From: Amanda Scholes on behalf of Planning.Responses
Sent: 28 September 2018 08:19
To: Planning Scanning
Subject: FW: Rustington REDW-3167-137
Attachments: REDW-3167-137.pdf

From: Steven Shaw [REDACTED]
Sent: 18 September 2018 15:55
To: Claire Potts
Subject: RE: Rustington REDW-3167-137

Following a review of the drawing it does not appear to be the same as that submitted for A/83/18/RES. The Redwood Partnership drawing number REDW-3167-137 differs in that:

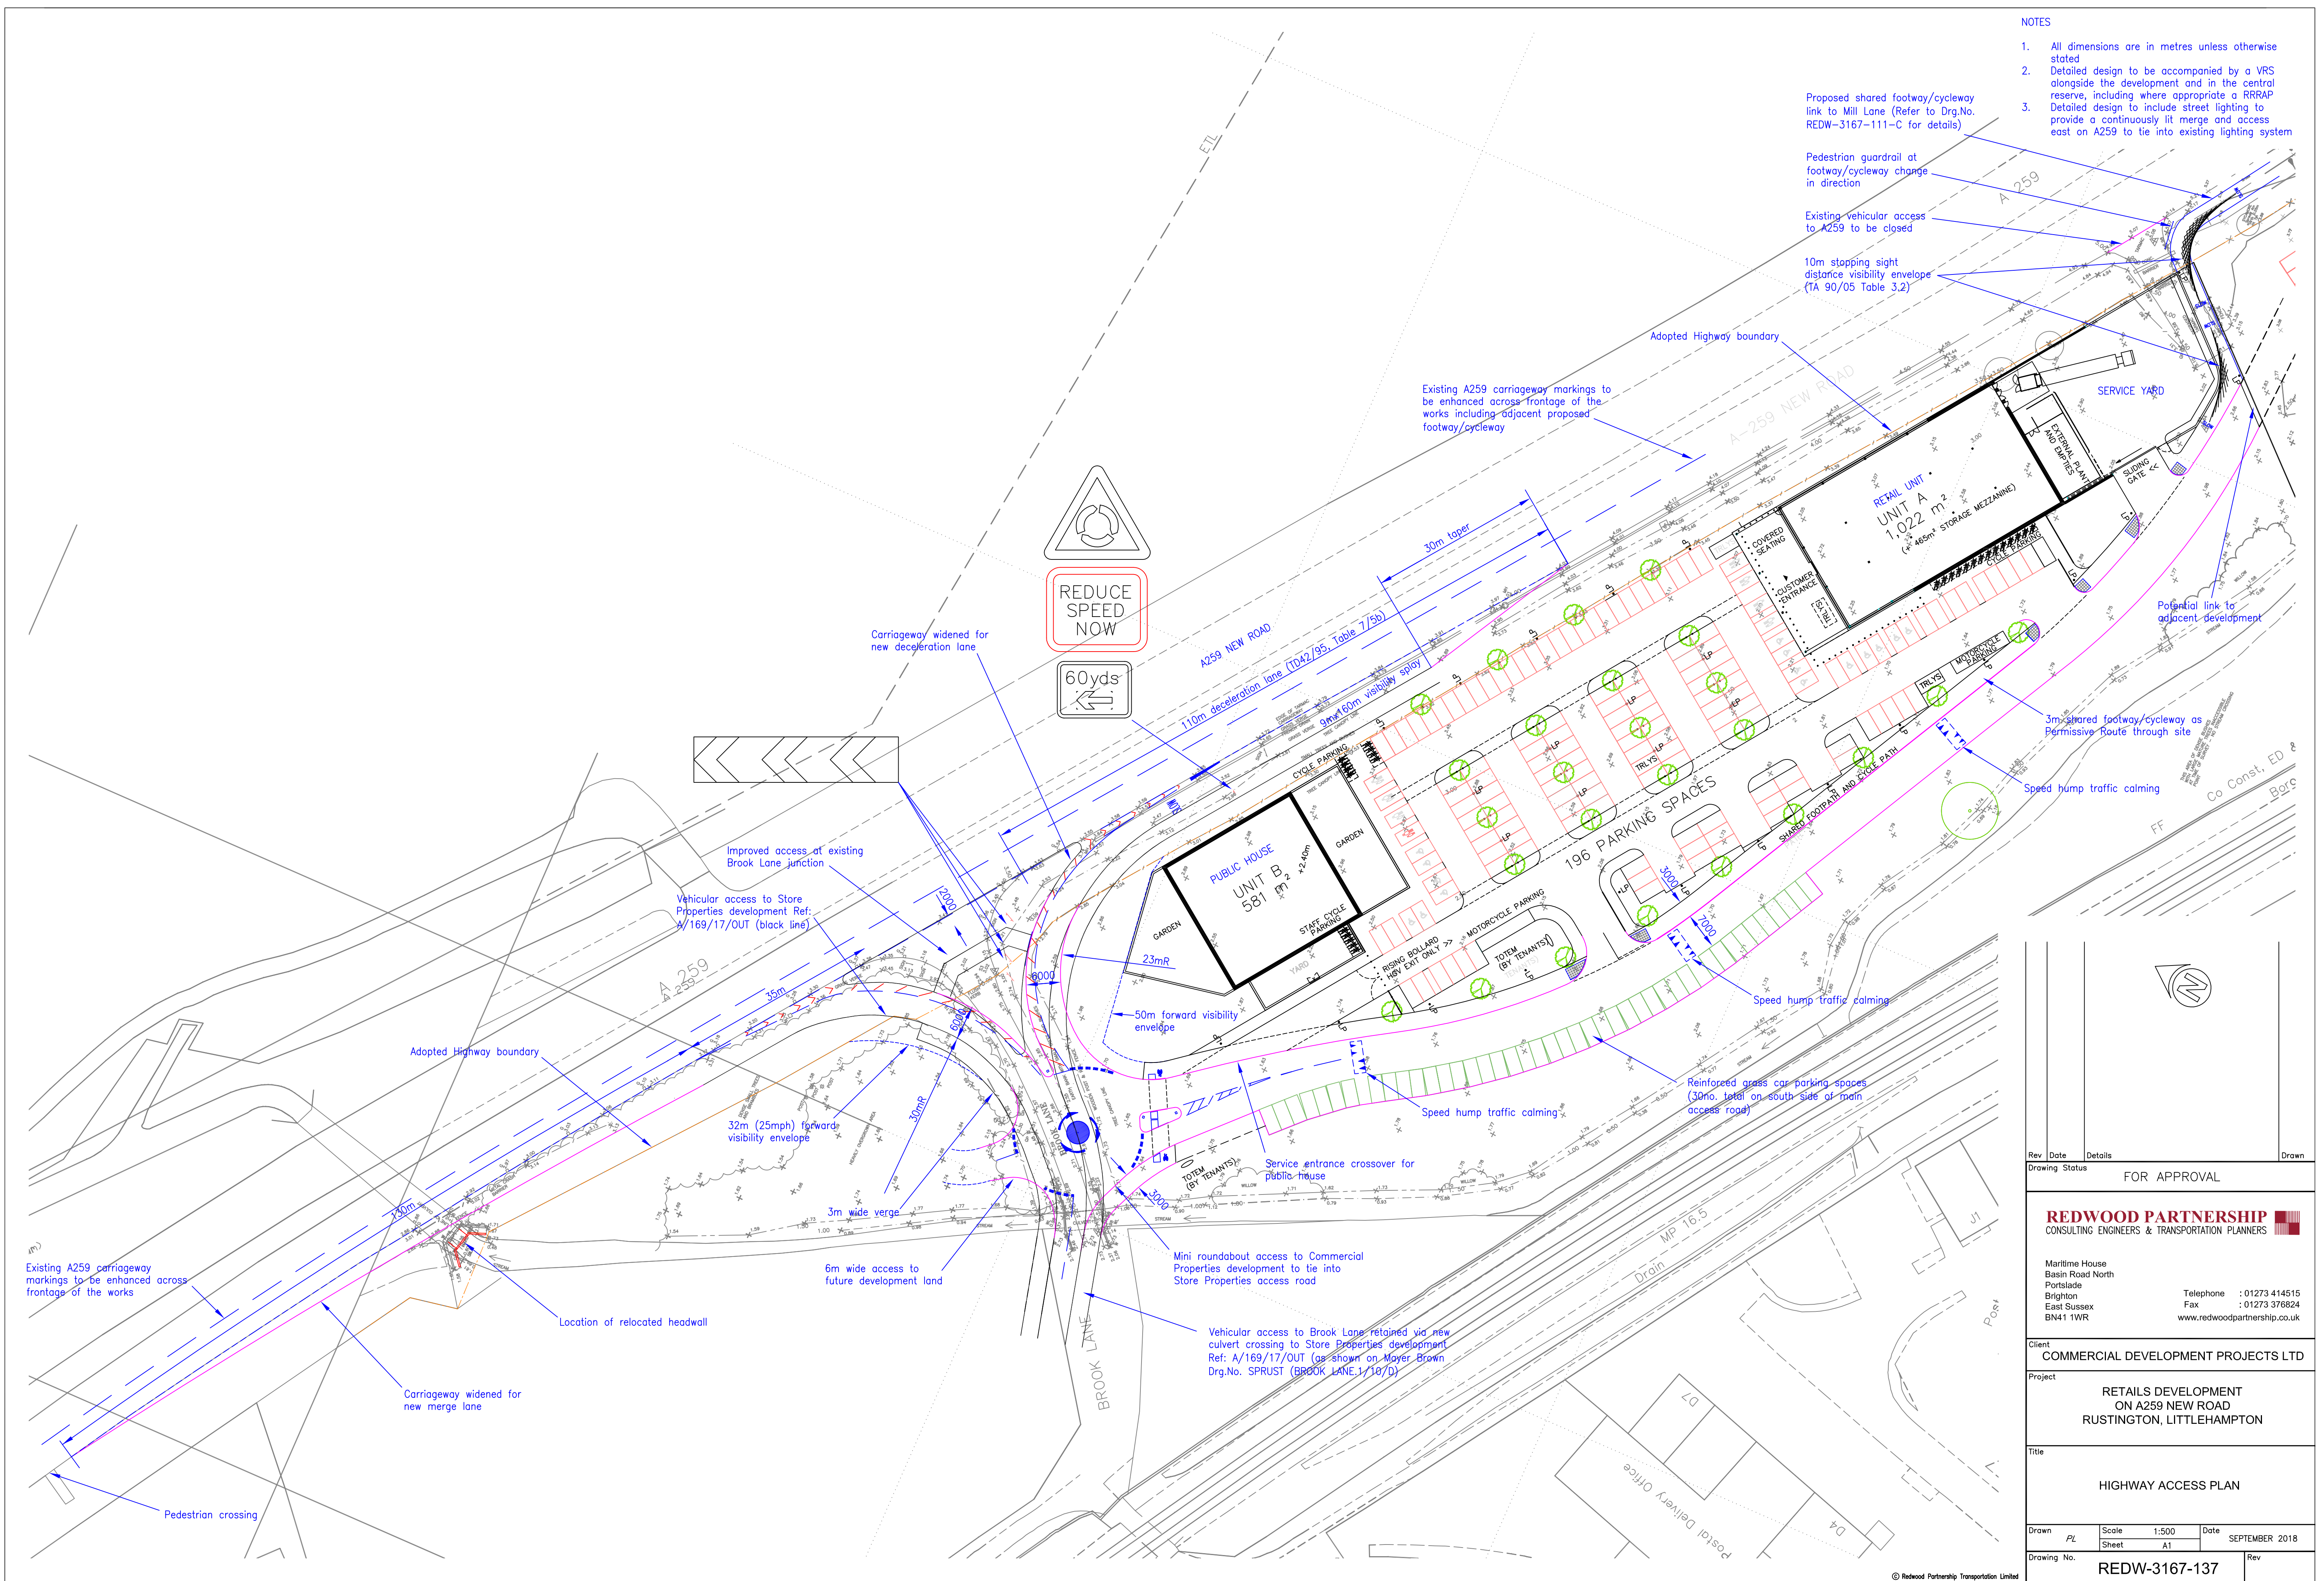
- **Radii** – the radii proposed is 23m when the one submitted for application A/83/18/RES is 30m. Therefore a revised drawing should be provided which provides a 30m radii. As per previous comments on application A/83.18/RES the applicant should ideally provide a justification for the 30m radius being less than the 40m stated as being 'preferable' in TD42/95 paragraph 7.54. It may be useful for the designer to know that the 85%ile measured wet weather speeds at diverge were previously measured at 105kph. This may form part of the justification for the reduced radius below.
- **Visibility splay** – a visibility splay of 9m x 160m is shown on the drawing but a splay of 9m x 295m should be indicated on the plans as being achievable.
